East Anglia TWO Offshore Windfarm

Best Practice Protocol for Minimising Disturbance to Red-Throated Diver

Applicants: East Anglia TWO Limited
Document Reference: ExA.AS-1.D7.V2
SPR Reference: EA2-DWF-ENV-REP-IBR-001049

Date: 4th March 2021
Revision: Version 02
Author: SPR / Royal HaskoningDHV

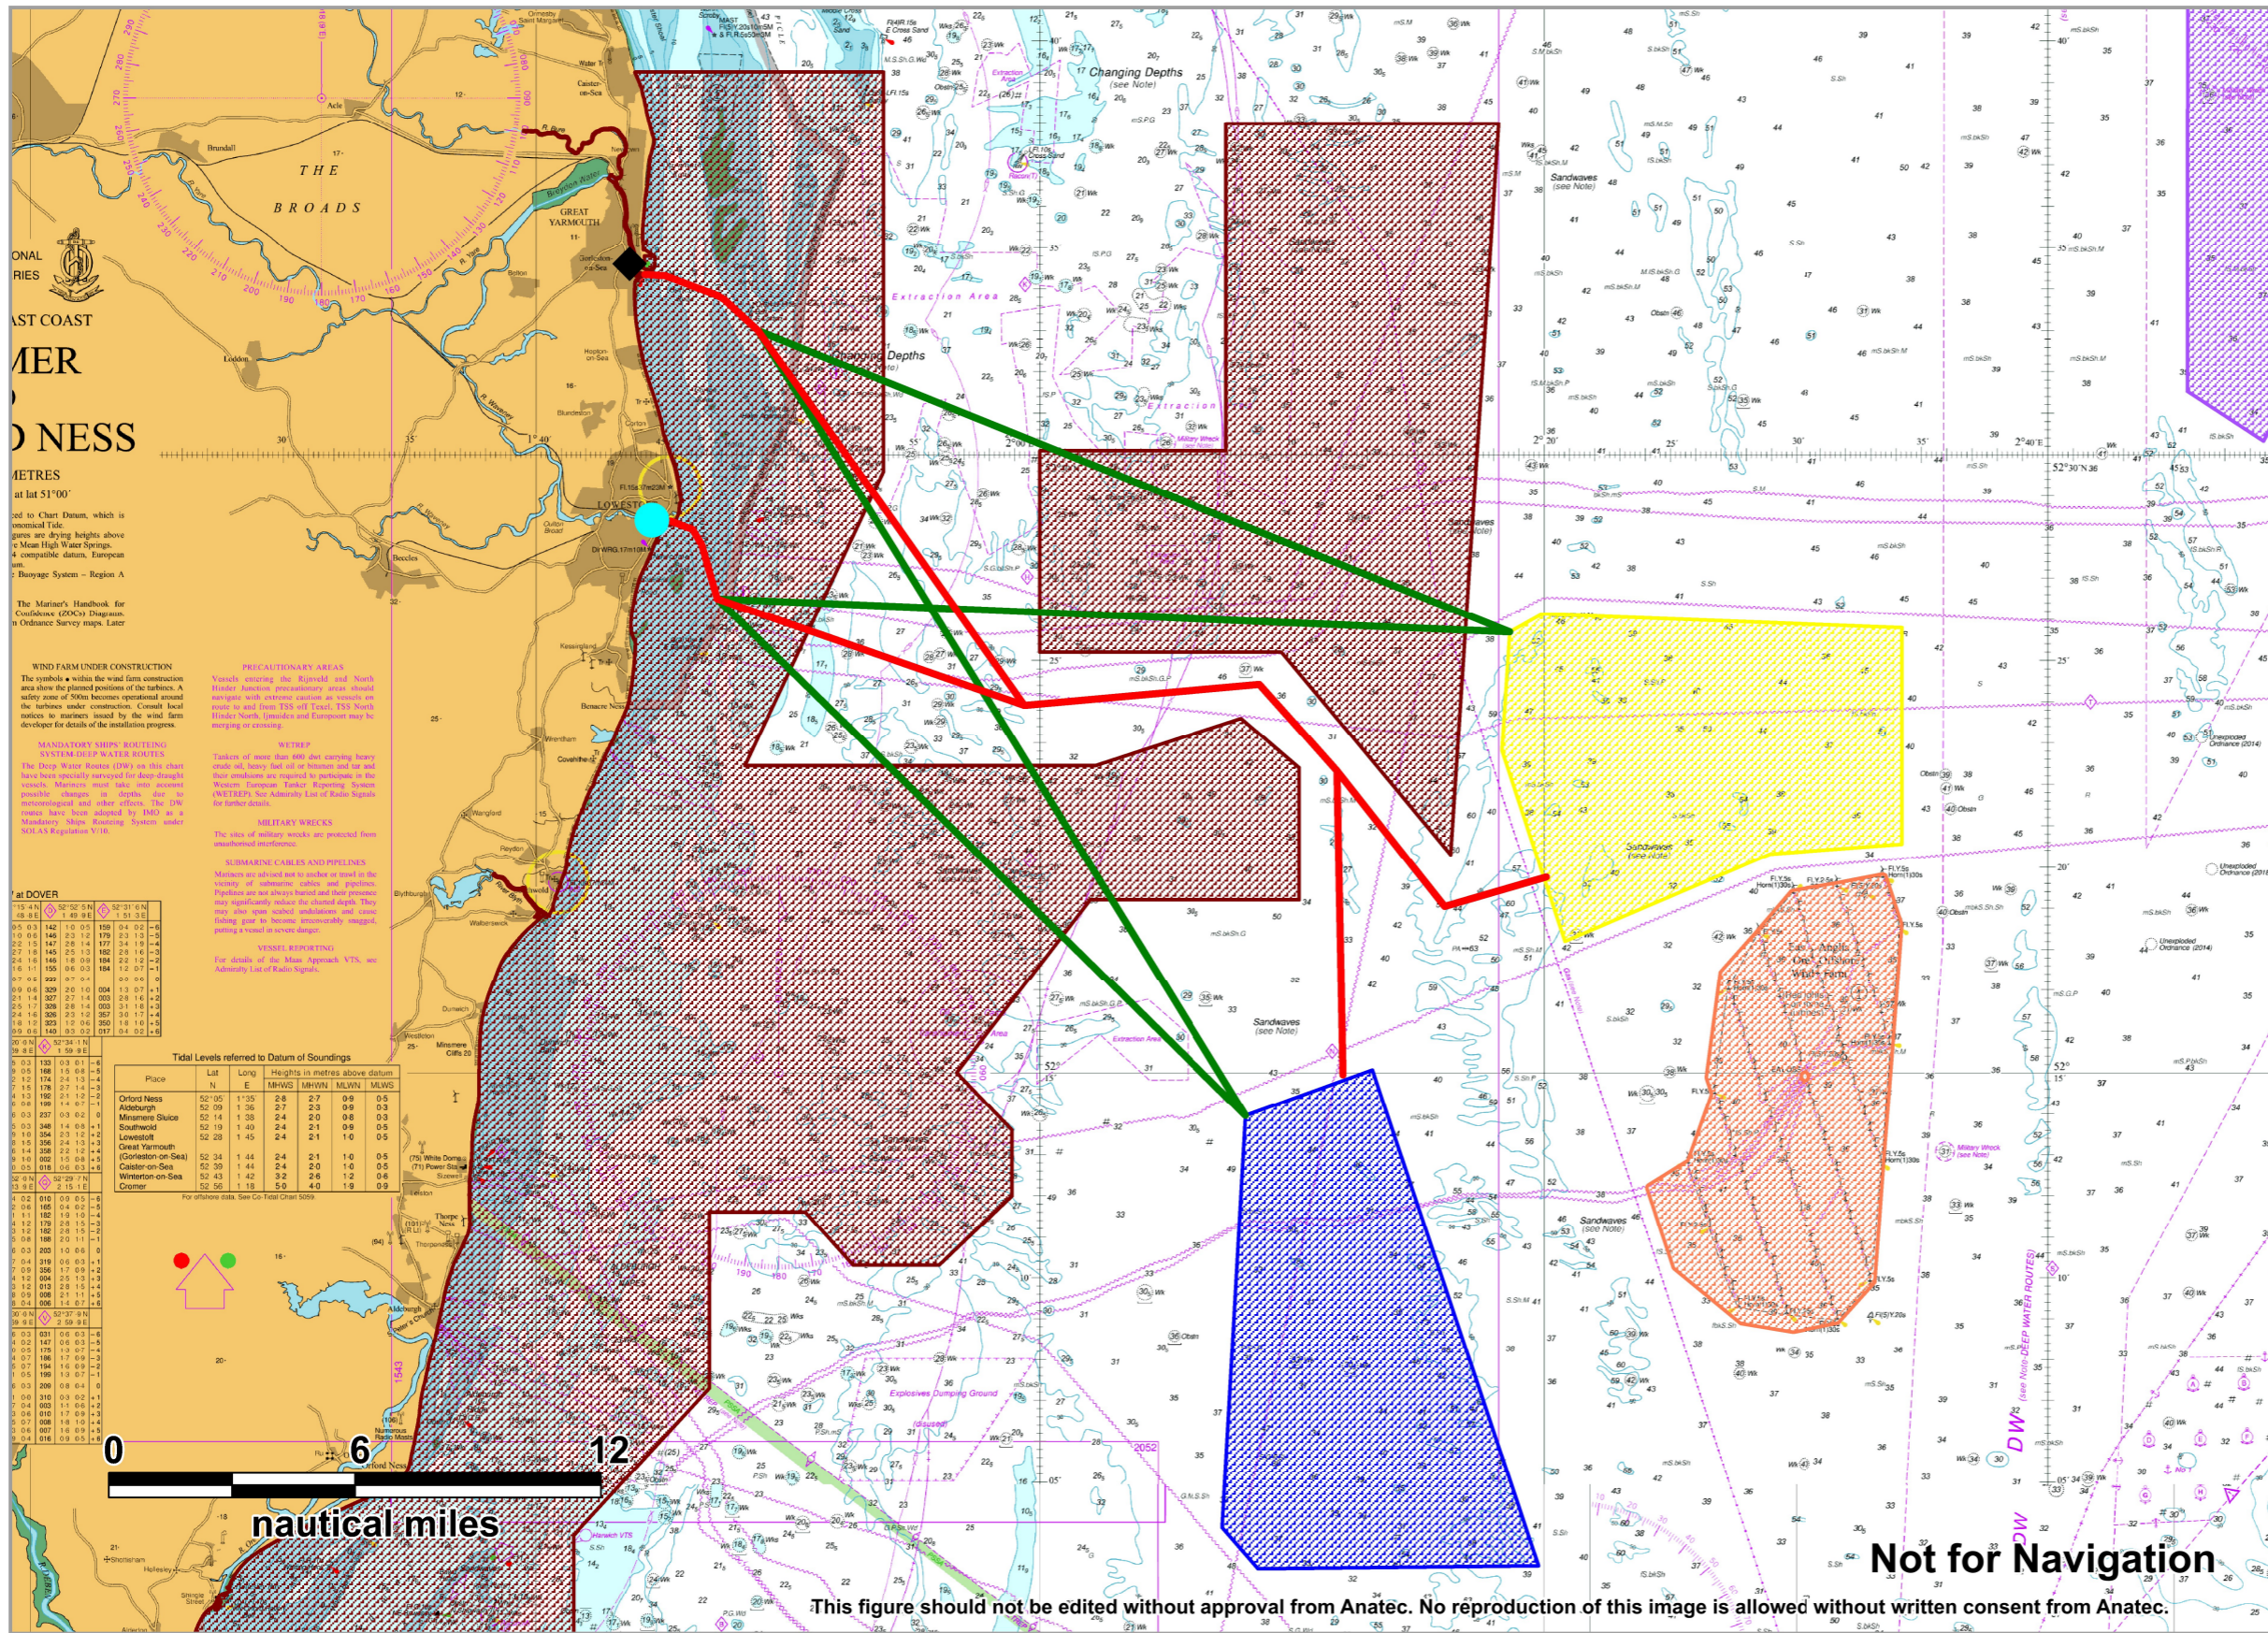
Natural England comment	Location where addressed
How will it be demonstrated that planned works during construction and operation phases are avoiding the sensitive periods between November and March?	Addressed in Section 2
Where it is not possible to avoid works during the sensitive period how will vessel movements be managed to minimise disturbance to SPA features?	Addressed in Section 2
Provide details of particular works when vessels will be required to leave existing navigational routes through the SPA	Addressed in Section 2
Low flying helicopter flights over the SPA are also likely to cause disturbance. If the use of helicopters is likely then we advise that is also covered under a protocol for minimising disturbance	Addressed in Section 3

Figure 1 where the anticipated 'direct routes' from each port to the windfarm site are shown in 'green' and the 'mitigation routes' in 'red'.

4. The main component of the SPA overlaps the approaches to both ports and therefore it is not possible to avoid transiting through this part of the SPA. However, the mitigation routes have been specifically created to follow the navigation approaches to both ports, and thus limit the impact of the Projects' vessel movements to areas of existing navigation routes associated with the ports, where the densities of red-throated diver are typically relatively low.

5. Once beyond the main components of the SPA, vessel traffic from either port has been routed through the gap between the main component and northern component of the SPA. This gap generally allows for a 4km width, with the exception at its narrowest where the gap is orientated northwest-southeast for a short section. At the point the gap is reduced to between 2.75 and 3.30 km, preventing a full 4km width. It should also be noted that alternative mitigation routes could also be used, but avoidance of the SPA beyond the approaches to the ports would be maintained.

7. The Applicant commits to implementing the measures outlined above and provided in **Figure 1** by all project vessels throughout the construction and operation of the Project through the core winter period of 1st November to 1st March inclusive.
